**KIRKLEES METROPOLITAN COUNCIL
INVESTMENT & REGENERATION SERVICE**

**DELEGATED DECISION FOR DISCHARGE OF CONDITION -
NOTIFICATION OF TELECOMMUNICATIONS DEVELOPMENT**

Reference no. 2023/N /90198/E

Description	Prior notification for proposed 5G telecoms installation: H3G 15m street pole and additional equipment cabinets
--------------------	--

215 PROPOSED SITE PLAN

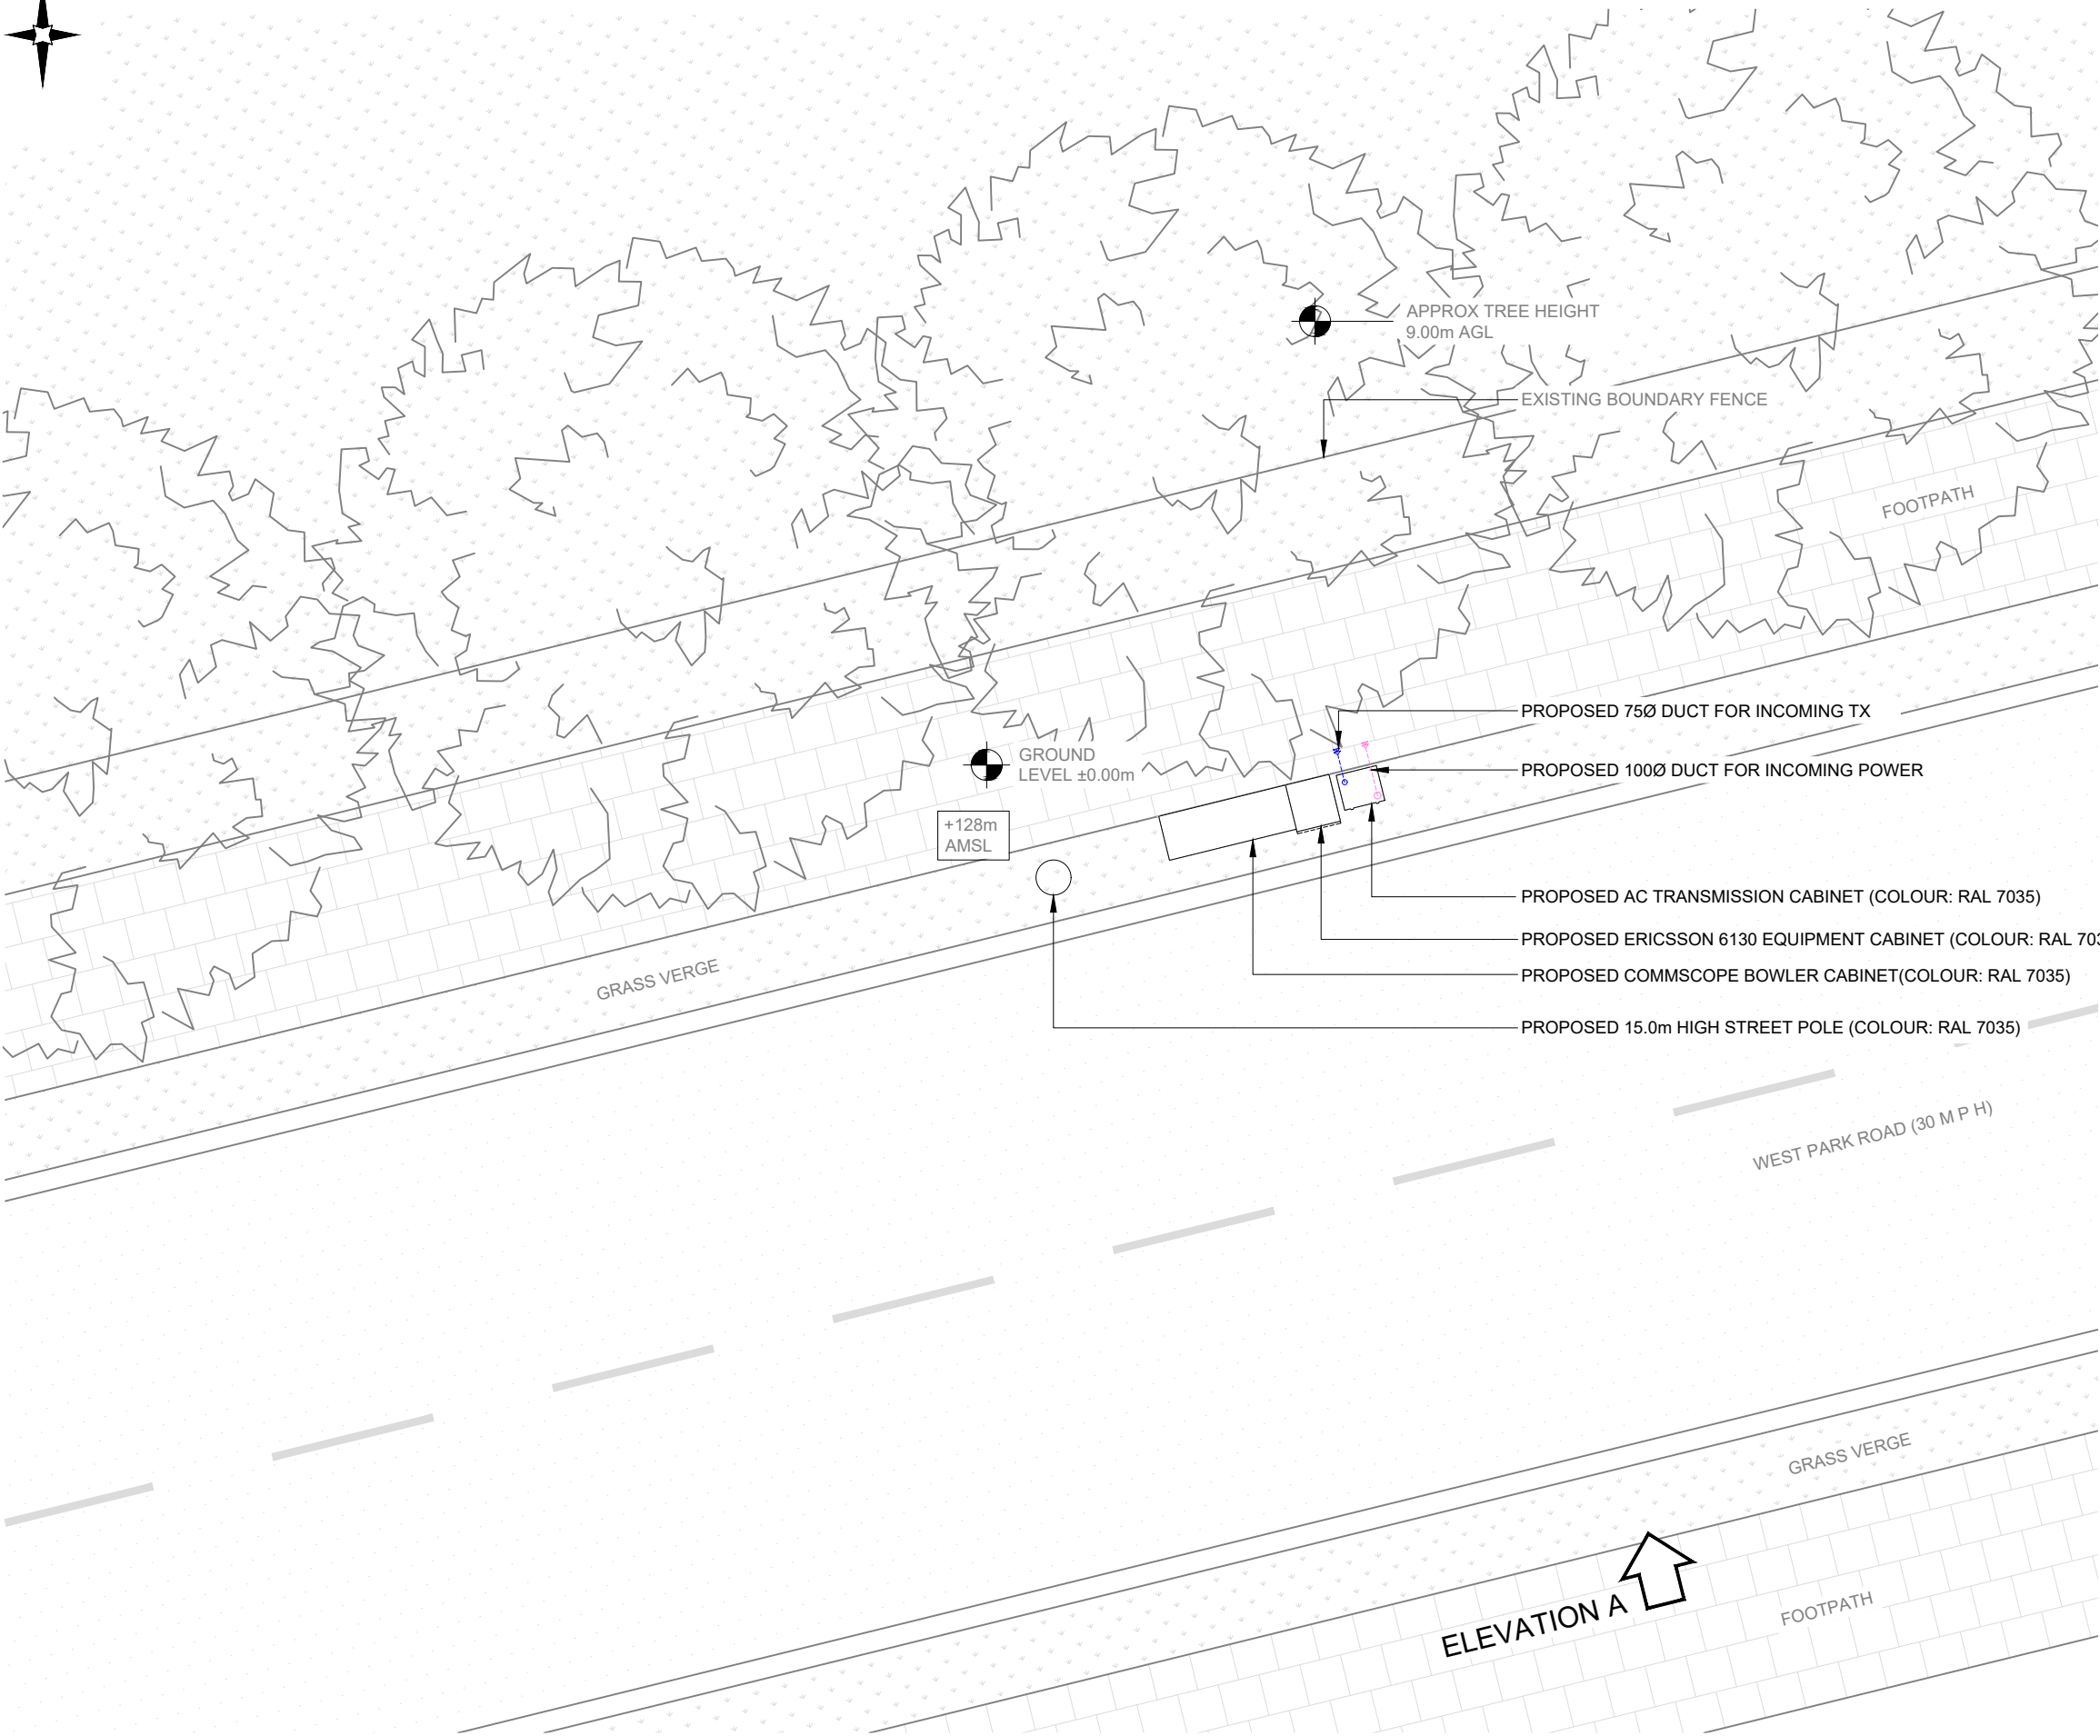
The mast would be located within an existing grass verge, marginally set back from the edge of the highway. Highways have been consulted on the application and have raised concerns regarding location of the proposal. The verge is approximately 1m wide and any equipment will need to be set back a minimum of 450mm from the kerb. Therefore, the equipment and mast cannot be sited wholly within the verge as shown on the plans submitted and will likely encroach onto the adjacent footway. KC Highways have requested additional information to check the scale of the proposed cabinets to ensure they would be contained within the grass verge or preferably sited on the grassed area adjacent to the school fields. However, it is considered that the installation of the mast on the opposite grassed area would not likely be possible by reason of the trees and would therefore need be located within the Highway. Consequently the proposed location would not be supported by the Council's Highway officers and is therefore contrary to Local Plan policy LP21.

The proposed location within the grass verge is unlikely to be supported by the Highway Authority by reason of the close proximity to the kerb. Consequently insufficient detail have been provided to assess the proposals potential impact to the Highway and is therefore contrary policy LP21 of the Kirklees Local Plan.

Title:
265 PROPOSED SITE ELEVATION

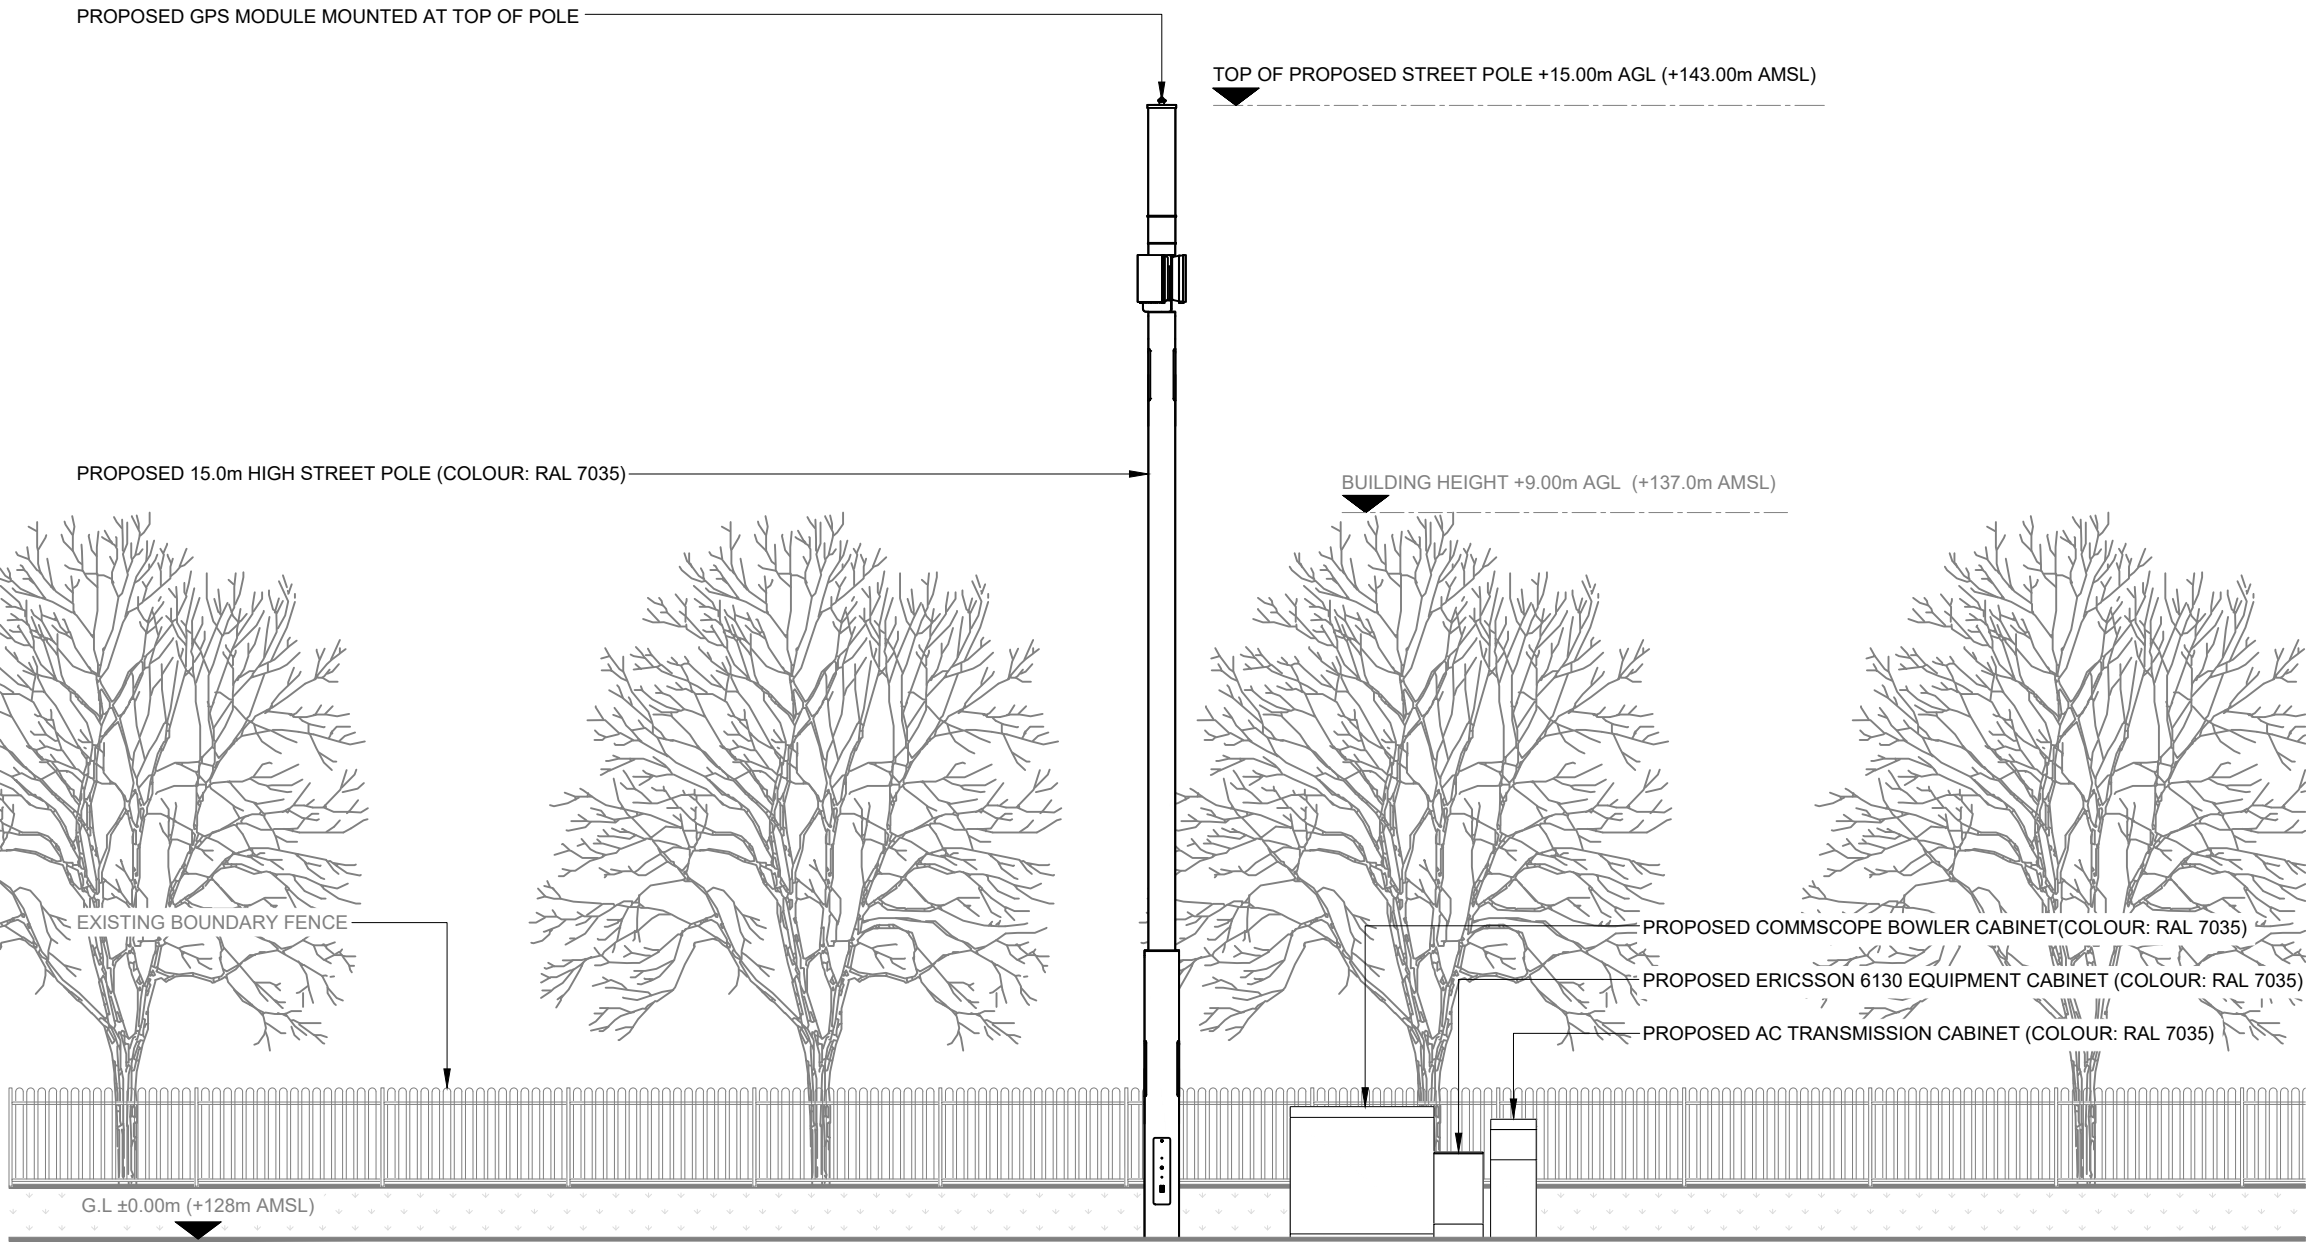
The new mast would be located within a grass verge adjacent to the Highway. The telephone poles and lighting columns within the immediate vicinity of the site are approximately half the height of the proposed mast. Similarly the mast would be 6 metres higher than the row of trees immediately behind the mast.

The mast would be located in a very prominent position within the public realm and would be significantly higher than all other features in the area and add additional 'clutter' within the street scene which is open in terms of its character and would therefore dominate the existing infrastructure. Moreover, there are a large number of residential properties in the area which are all two-storey in height but significantly lower scale than the proposed development. The introduction of the 15 metre mast into this low lying residential area would therefore appear incongruous within the street scene. The proposed siting of the mast on the grass verge between the carriageway and footpath also exacerbates the prominence of the mast.

In addition to the overt appearance of the mast, the open nature of the site without screening or a change in topography which may reduce the prominence of the mast the 15 metre mast would be significantly visible for some distance along West Park Road.

In this instance it is considered the mast is significantly overt and dominant on the streetscene. As the applicant has not fully demonstrated an alternative location on nearby industrial buildings cannot be considered, the benefit of quality infrastructure does not outweigh the harm to visual appearance within the chosen location.

The proposed mast, by reason of its siting, overall height and appearance, would introduce a visually intrusive and incongruous feature within the street scene, appearing out of scale with the surrounding development and failing to respect the open character of the streetscape and wider area. This harm is not outweighed by the benefit of quality telecommunication infrastructure as the applicant has not fully demonstrated the mast and equipment could not be located at a more suitable site within the vicinity of the proposed location. The
